Ribble Valley Borough Council
By email

Your ref: 3/2023/0153
Our ref: DC/23/857 v2
Date: 02-AUG-23

Location: Old Row Whalley Road Barrow BB7 9AZ

Proposal: Proposed erection of a 66 bed care home (use class C2) for elderly people with associated parking alongside the erection of 3 dwellings following the demolition of nos. 23-25 Old Row

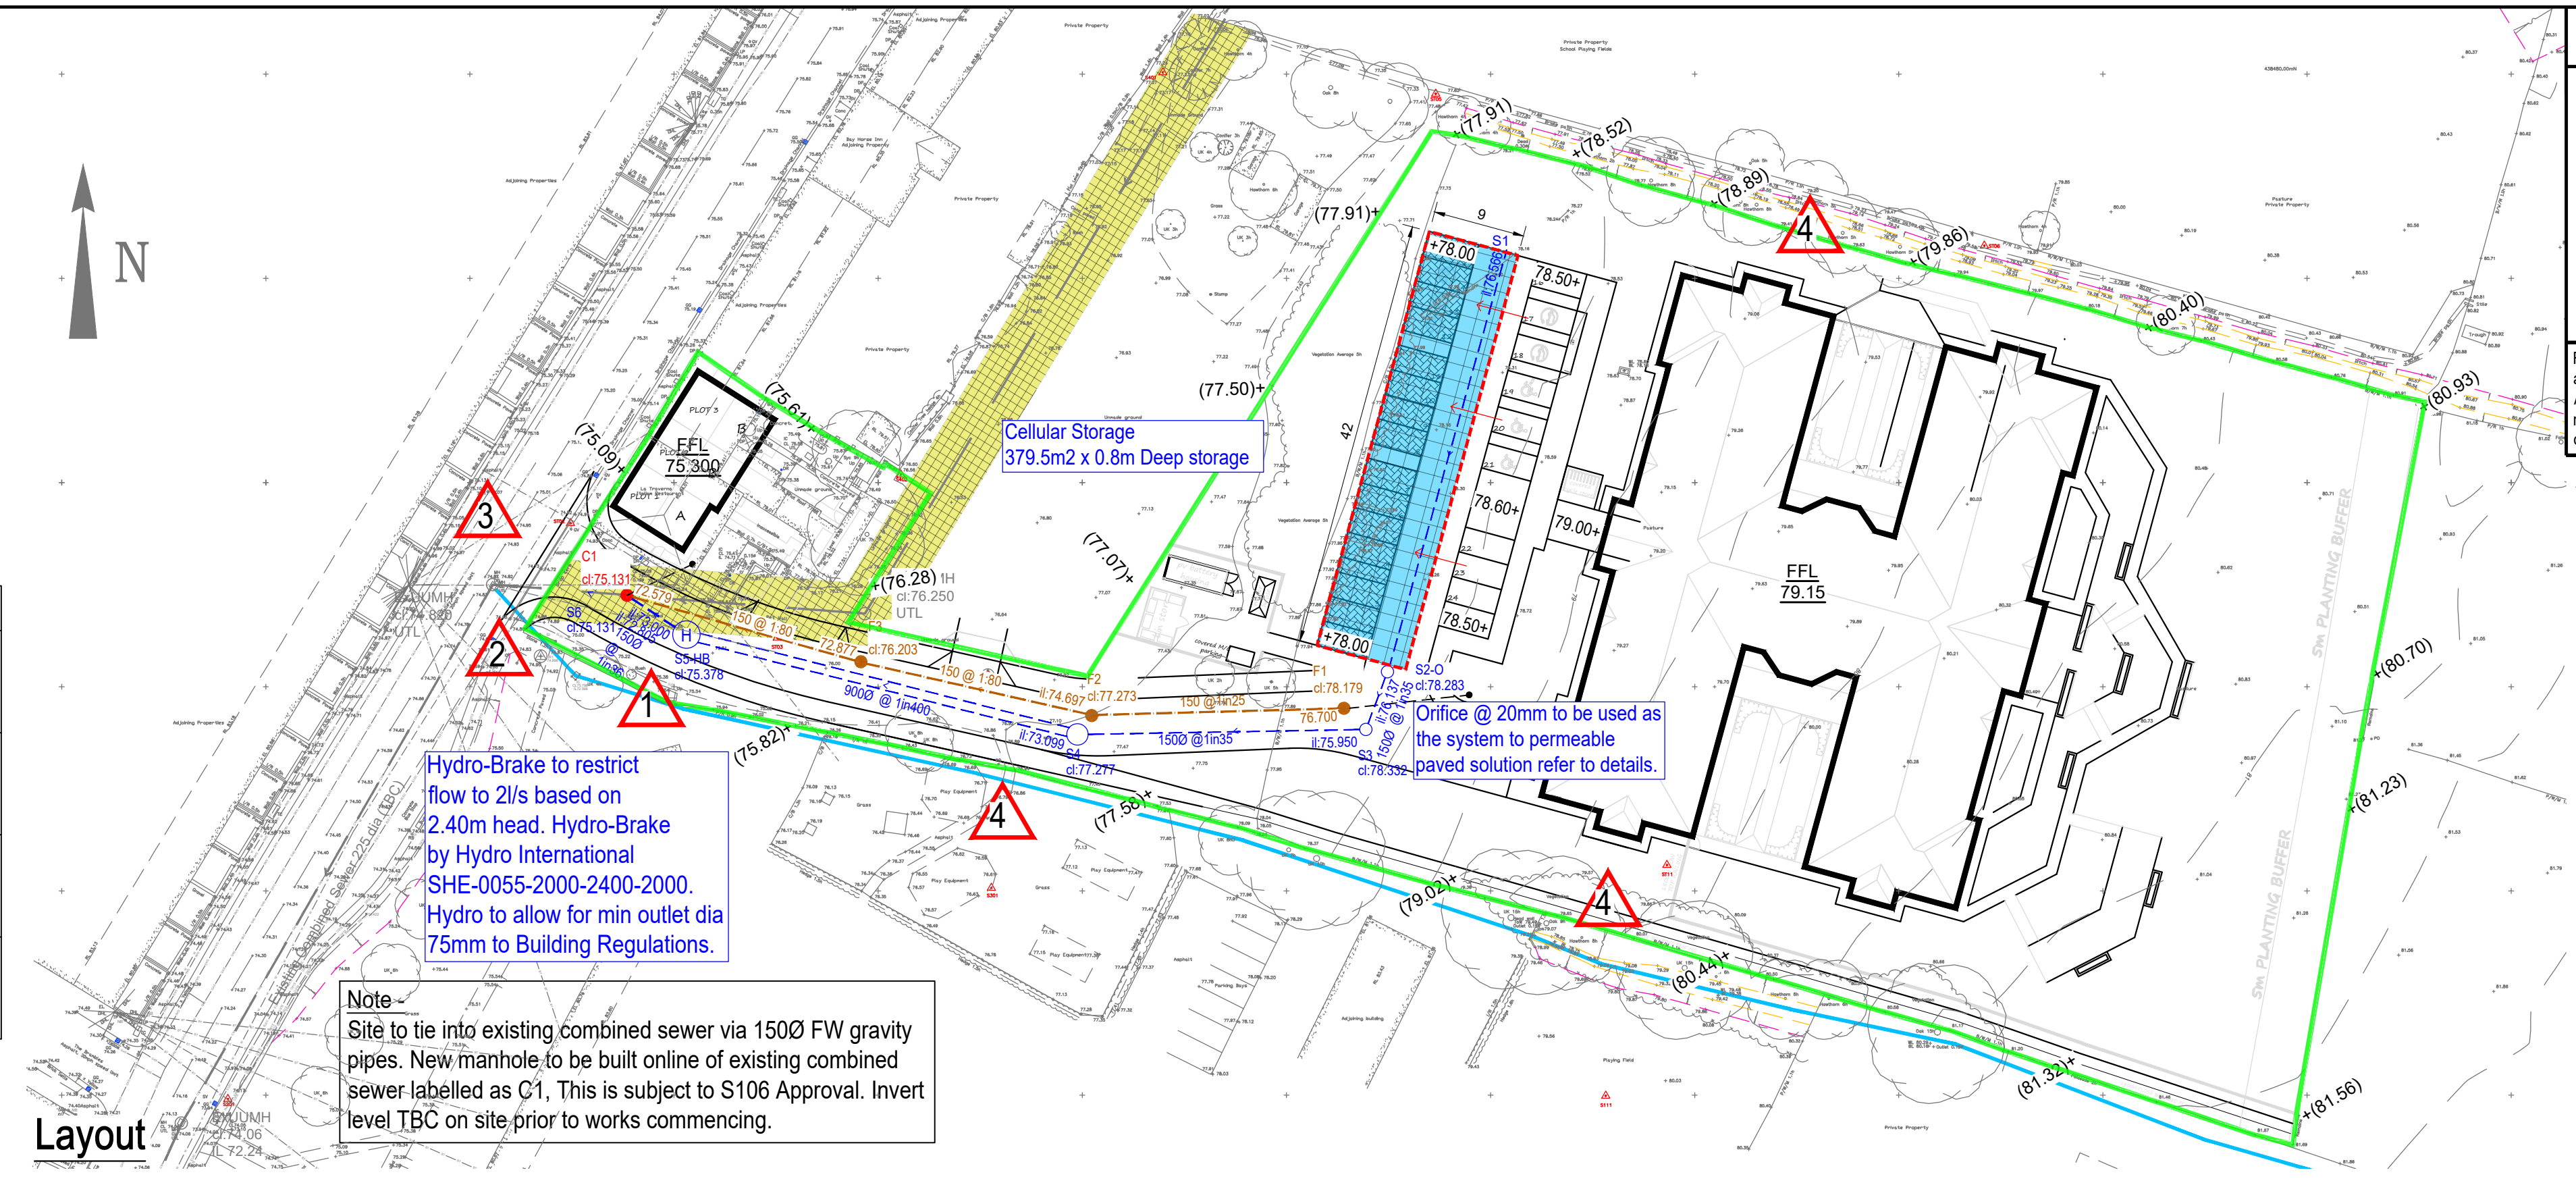
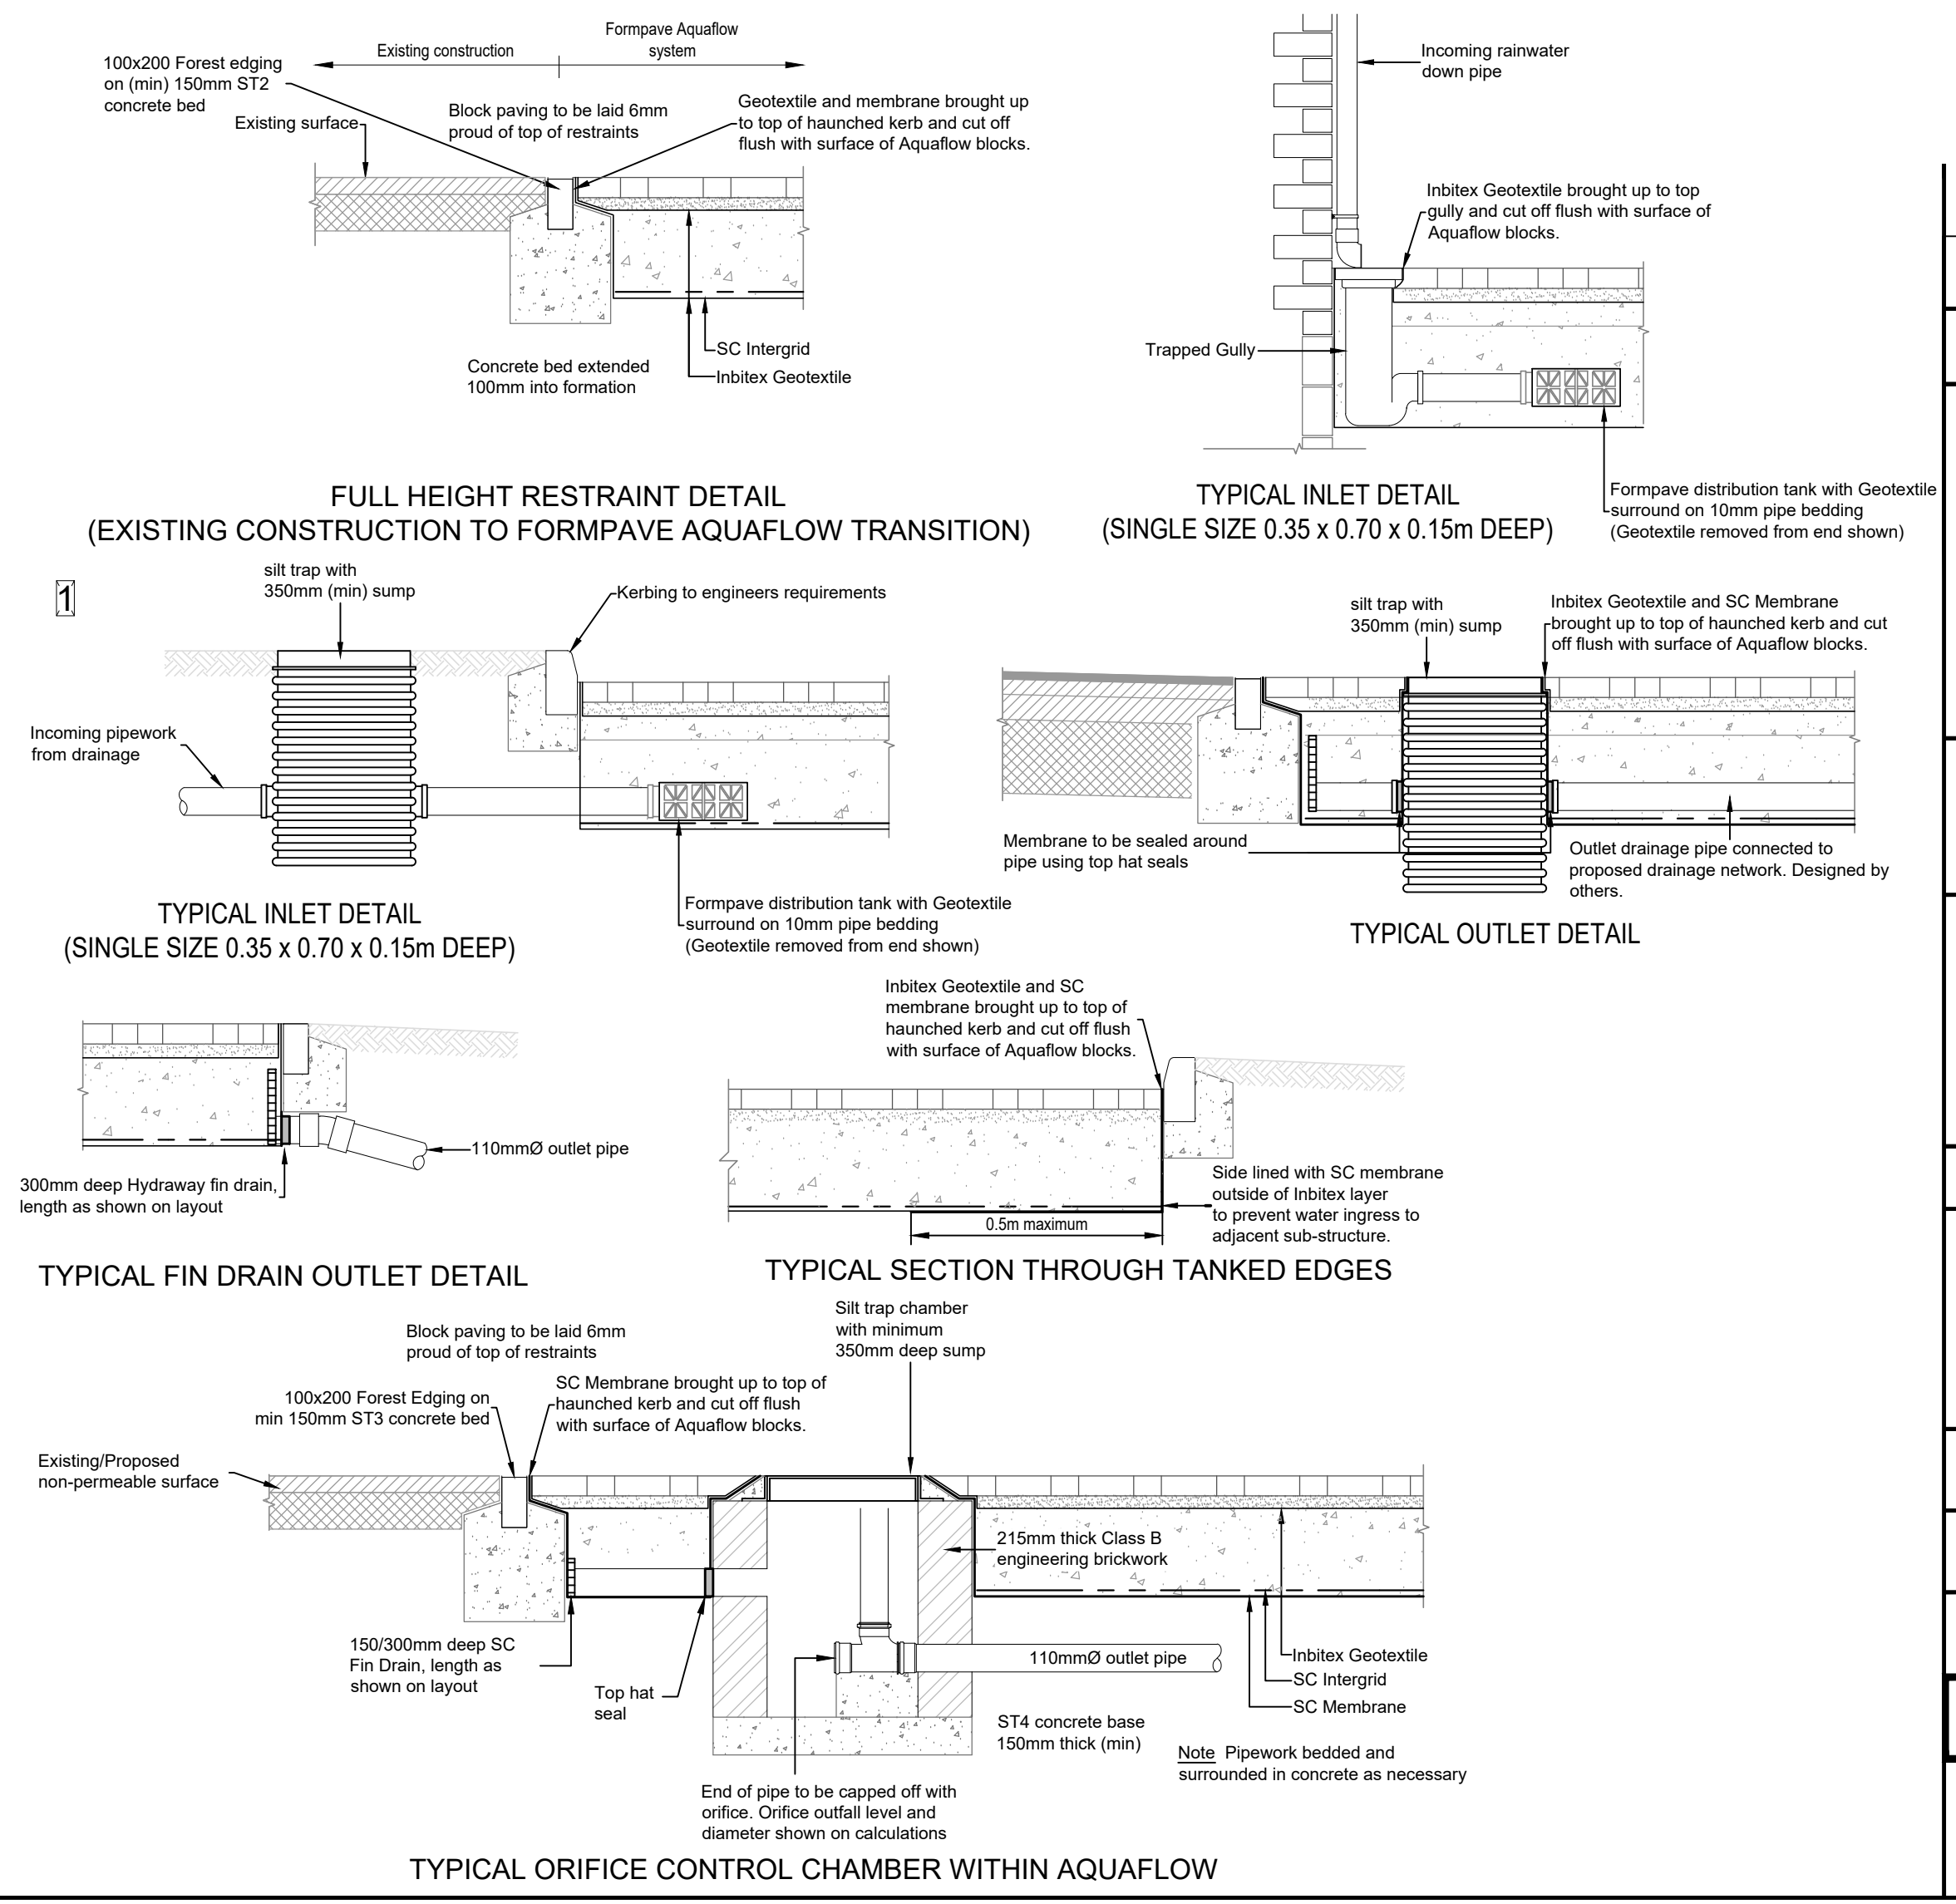
Following our review of the proposed site layout, we have concerns regarding the proximity of proposed development to our water assets. To resolve this matter, and to avoid any unnecessary costs or delays to either the applicant or any future developer, we request the applicant submits a detailed site layout plan which overlays the proven location of the water main in relation to any proposed development (including walls, fencing, parking etc.). Without this information we are unable to provide further comment and there is a risk that as the scheme progresses, the applicant, or any subsequent developer, may discover that their plans are not implementable in their existing form or that diversion of assets is required. Therefore, we strongly recommend this matter is resolved PRIOR TO DETERMINATION.

A public sewer crosses the site and we will not permit building over it. We require an access strip for maintenance or replacement and this access must not be compromised in any way. The minimum distances that might be acceptable to United Utilities are detailed within Part H of the Building Regulations however, we recommend the applicant determines the precise location, size, depth and condition of the pipeline as this is likely to influence the required stand-off distance from any structure.

The drainage for the development hereby approved, shall be carried out in accordance with principles set out in the submitted Foul & Surface Water Drainage Design Drawing 10-01, Rev P01 - Dated 1/06/23 which was prepared by RSK. For the avoidance of doubt surface water must drain at the restricted rate of 2 l/s. Prior to occupation of the proposed development, the drainage schemes shall be completed in accordance with the approved details and retained thereafter for the lifetime of the development.
